City of Albuquerque Stormwater Construction Site Inspection Report

General Information					
ESC File No.	K09E048D		Project Name:	Caliber Collision	
NPDES Id. No.	NMR100607 & 08		Location:	250 98th St NW	
9/19/2024	Owner		Contractor		
Operator	Cross Development CC Albuquerque, LLC		Madewell Construction		
Contact name & title	Joe Dell		Paul Hubbard		
e-mail	Joe@crossdevelopment.net		paul@madewell-construction.com		
Contact Phone #	214-762-1824		937-798-1475		
COA Inspector	Doug Hughes		Time	10AM	
Construction Phase:	grading				
Type of Inspection:	Regular	Storm Event	Post Storm Event >0.25"	311/Complaint	Follow Up
Weather at time of inspection?			Temperature: ~ 69		
Estimated date of last storm 0.25" or greater			8/27/2024

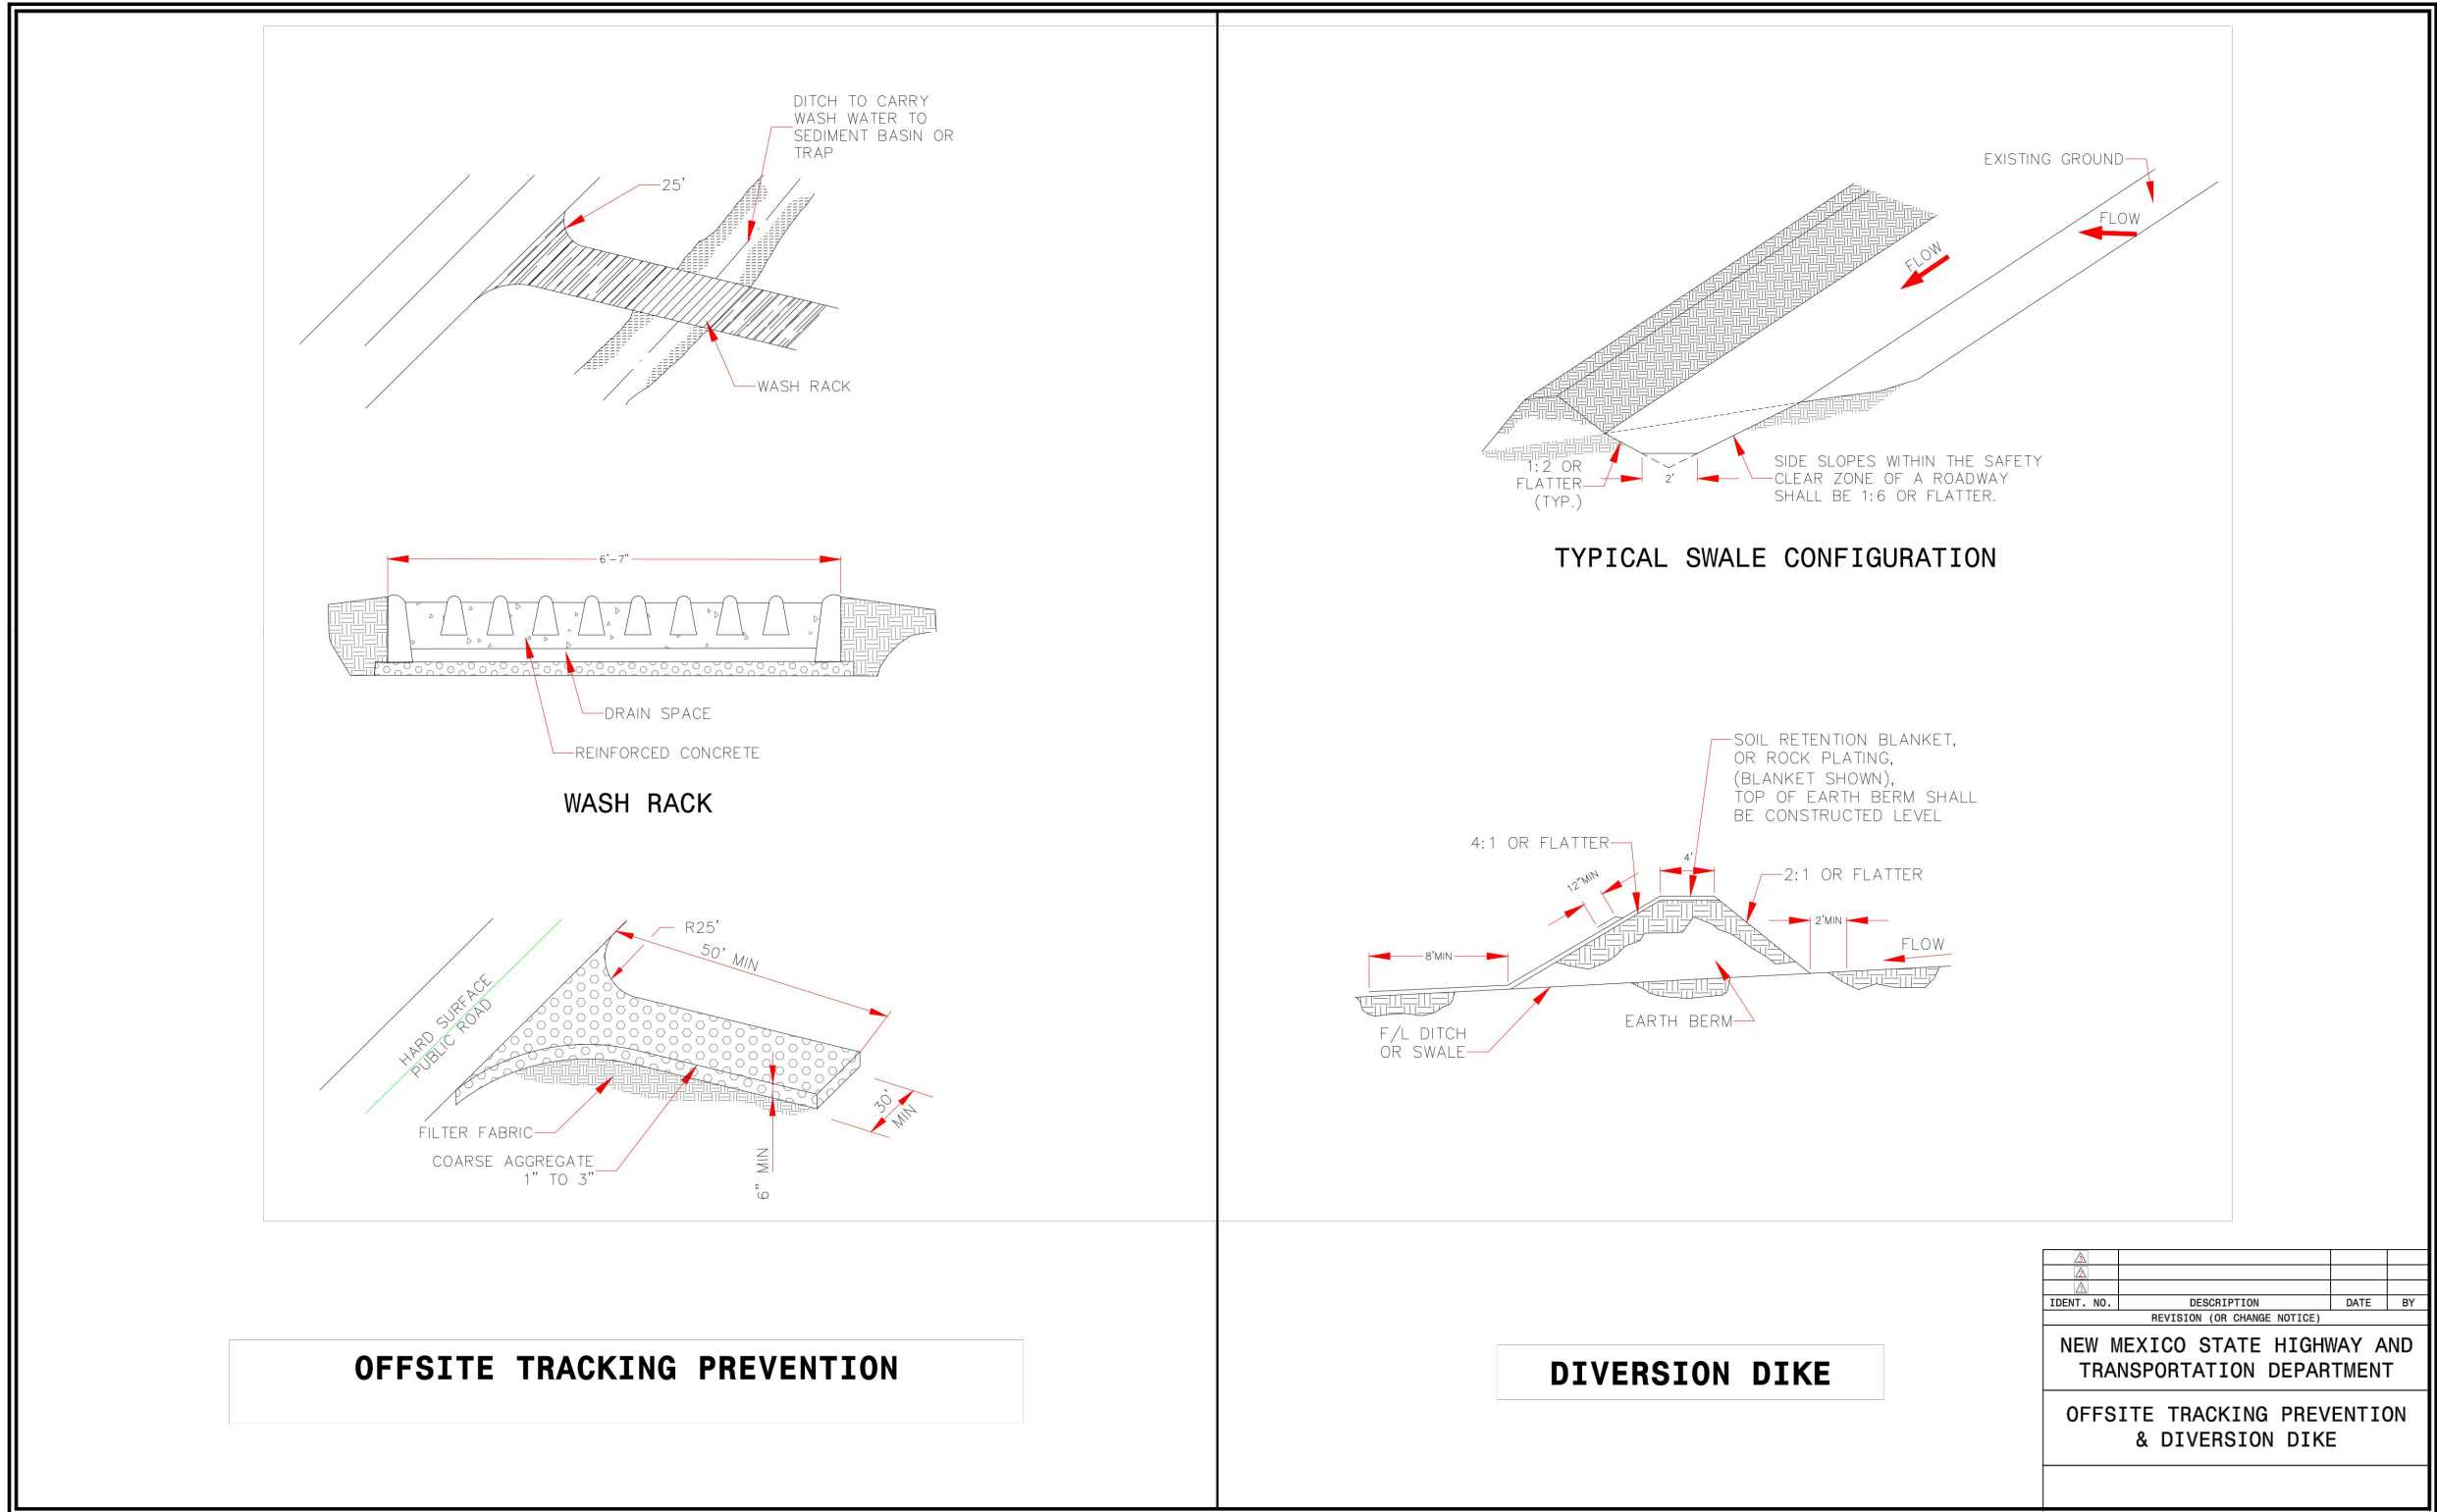
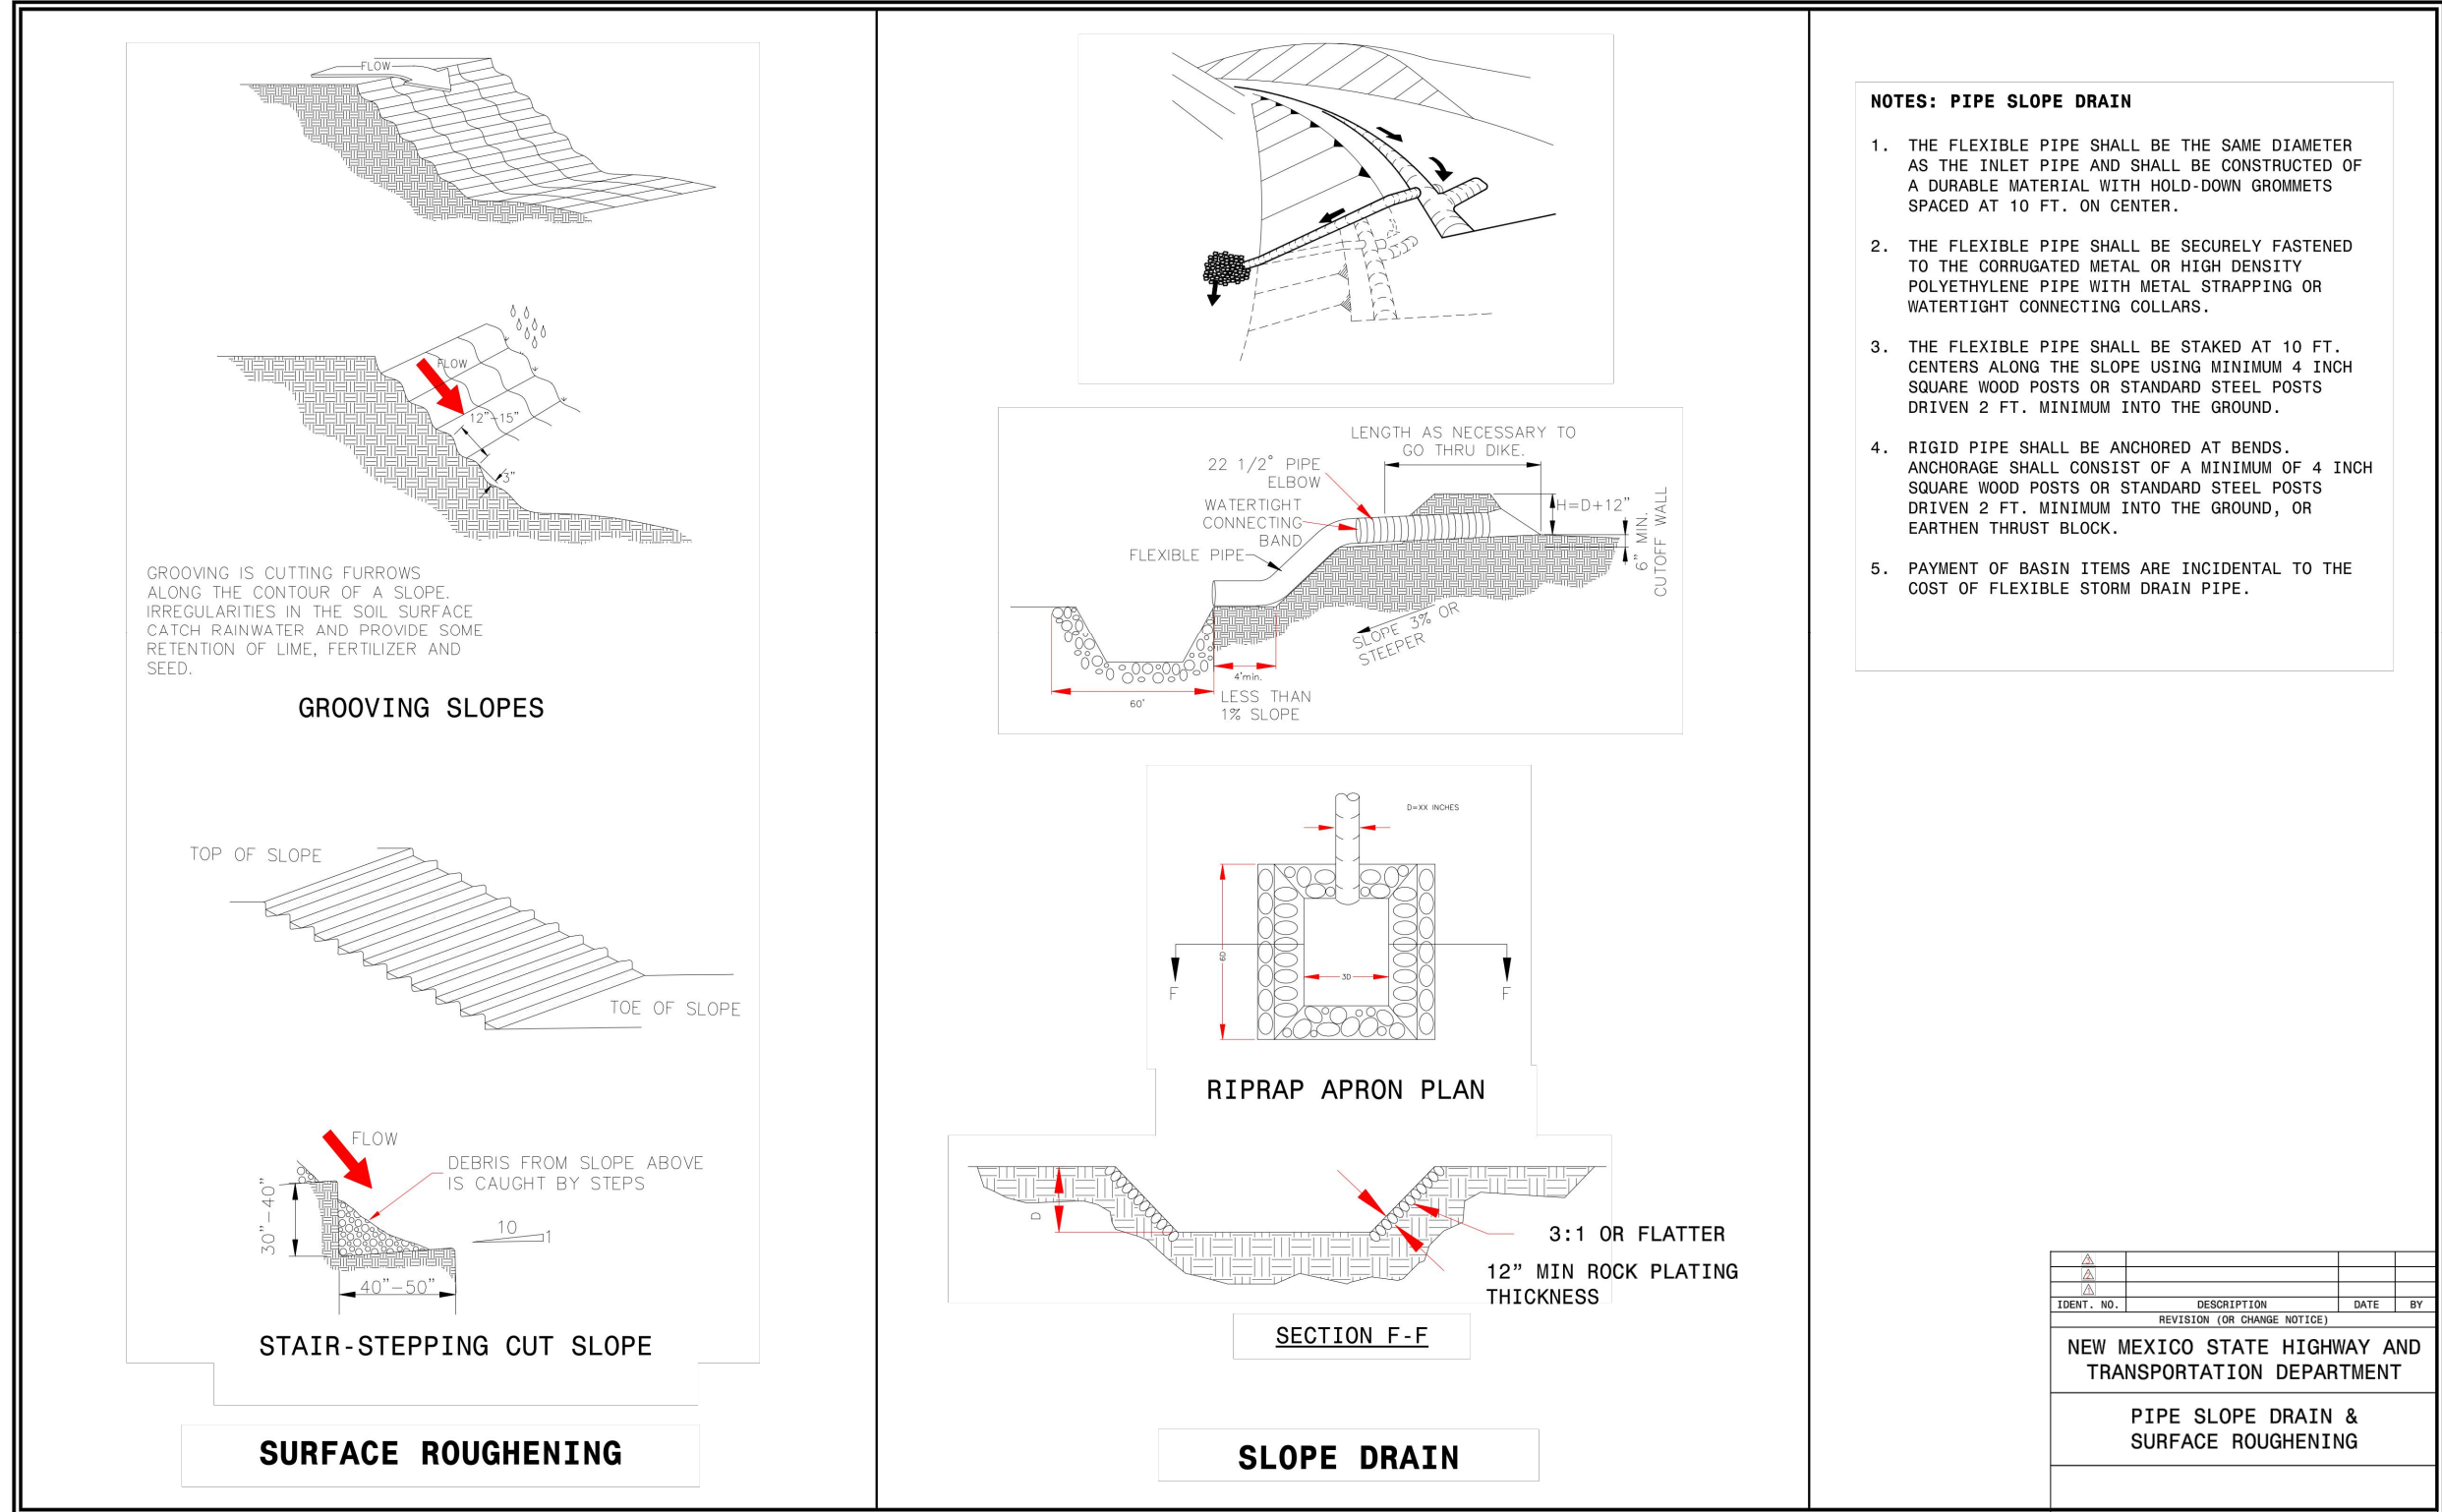
Item Number	Deficiency/ Corrective Action				
2	Stabilization —All perennial vegetation was removed from this site as part of the subdivision development that started in late 2022, and it was not replaced, so this site was still under permit coverage when this project started. The south half-acre is inactive and not properly stabilized in violation of CGP 2.2.14. Weeds in that area are in violation of the Weed, Litter, and Snow Removal Ordinance (§ 9-8-1). Required Mitigation: Stabilize the inactive disturbed areas and “large bare areas” per CGP 2.2.14.c.i. Implement and maintain stabilization measures in areas that remain inactive for 14 days or more. Measures must be initiated within 14 days and completed no later than 14 days per CGP 2.2.14.				
2	Sediment —Dirt was in the street at the construction exit and not removed within 24 hours in violation of CGP 2.2.4.d. Dirt ramps are prohibited. Required mitigation: Remove sediment deposited in the streets by the end of the same business day. Remove the sediment by sweeping, shoveling, or vacuuming these surfaces or using other similarly effective means of sediment removal. You are prohibited from hosing or sweeping sediment downstream per CGP 2.2.4.d.

3	BMPs - The Silt Fence was missing around the south half acre of the site in violation of CGP 2.1. Earthwork had blocked the temporary diversion swale on the east side of the property, potentially creating a new erosive discharge point into the neighbor's property to the east in violation of CGP 2.2.11. Required mitigation: If at any time you find that a stormwater control needs routine Maintenance, you must immediately initiate the needed maintenance work and complete such work by the close of the next business day. When the problem requires a new or replacement control or significant repair, install the new or modified control and make it operational or complete the repair by no later than seven (7) calendar days from the time of discovery per CGP 5.2.1.				
4	SWPPP - The SWPPP wasn't up-to-date in violation of CGP 7.1, and the self-inspection reports were missing in violations of City Ordinance § 14-5-2-11(C)(1) and CGP 4.7.3. The operator's SWPPP certification was missing in violation of CGP 7.2.10 The 2022 CGP wasn't available in violation of Violation of CGP 7.2.11.c. The operators deligated signatory authority to E2RC which isnt allowed because E2RC is a third Party per Required Mitigation: The SWPPP, including the SWPPP Map, Self Inspection Reports, and Corrective Action Reports, must be kept up-to-date per CGP 7.1 and available on-site per CGP 4.7.3, 5.4.3 and 7.3. If an on-site location is unavailable to keep the SWPPP when no personnel are present, notice of the plan’s location must be posted near the main entrance of your construction site CGP 7.3.

2.1	Discharge off site? (Y/N)	yes			
4	Self Inspection Reports	requested	Latest report Date:	missing	
Notes:					
Washout container was missing.
